Engineers Comments re Drainage etc.

APPLICATION NO: LU/252/19/PL

Site Address: Yeomans Honda Horsham Road Littlehampton BN17 6DN

Description of Works: Removal of existing low level brick wall, existing forecourt wall to be reduced in height & graded back into the site, part of forecourt & parking areas to be overlaid with a Dense Bitumum macadam (DBM) Wearing Course, parking spaces to be delineated with white thermoplastic paint & site frontage to be secured with bollards.

Drawing
PROPOSED SITE PLAN

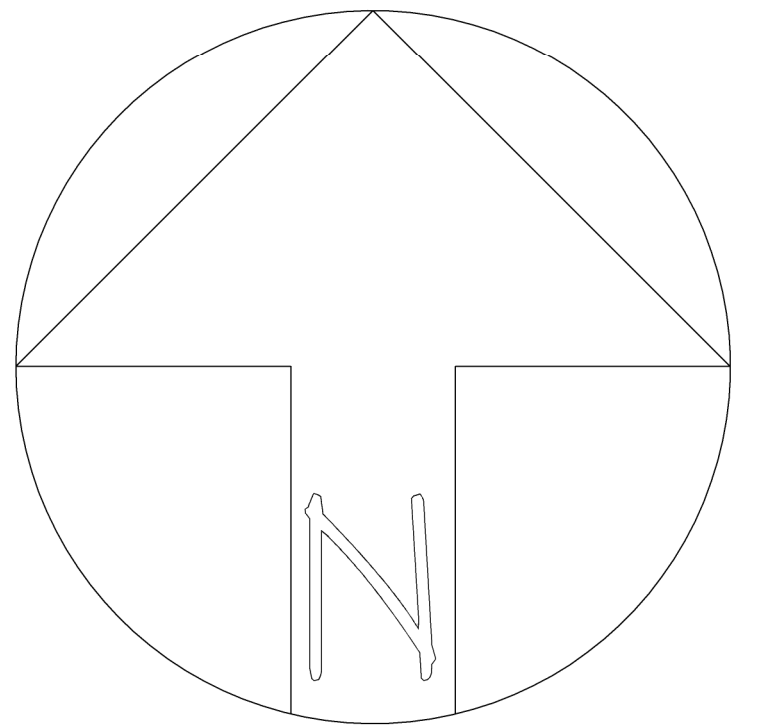
Given that the area of the forecourt that is to be regraded was previously occupied by a petrol filling facility, I am surprised that the Application shows 'no' to all points regarding contamination. Perhaps it was fully remediated when the filling facility was removed (1992?)

I am also concerned that the application shows surface water going to 'main sewer'. There is no public surface water sewer in Horsham Road, thus the proposal is seemingly to discharge to the combined sewer, although this is not detailed.

It is right that the run-off (which may also include some of the roof area of the existing building) should not discharge to the highway – as it would if the channel drains were not in place - any connection to foul or combined sewers should be avoided and the normal hierarchy of surface water disposal should be followed if at all possible. There would seem to be sufficient area to provide infiltration although we are not provided with groundwater or permeability data to assess this.

The existing arrangement should be investigated; whilst it may be that the existing slot drains may discharge to the 'main sewer', we should be seeking betterment and endeavouring to have surface water flow removed from the combined sewer as part of this development.
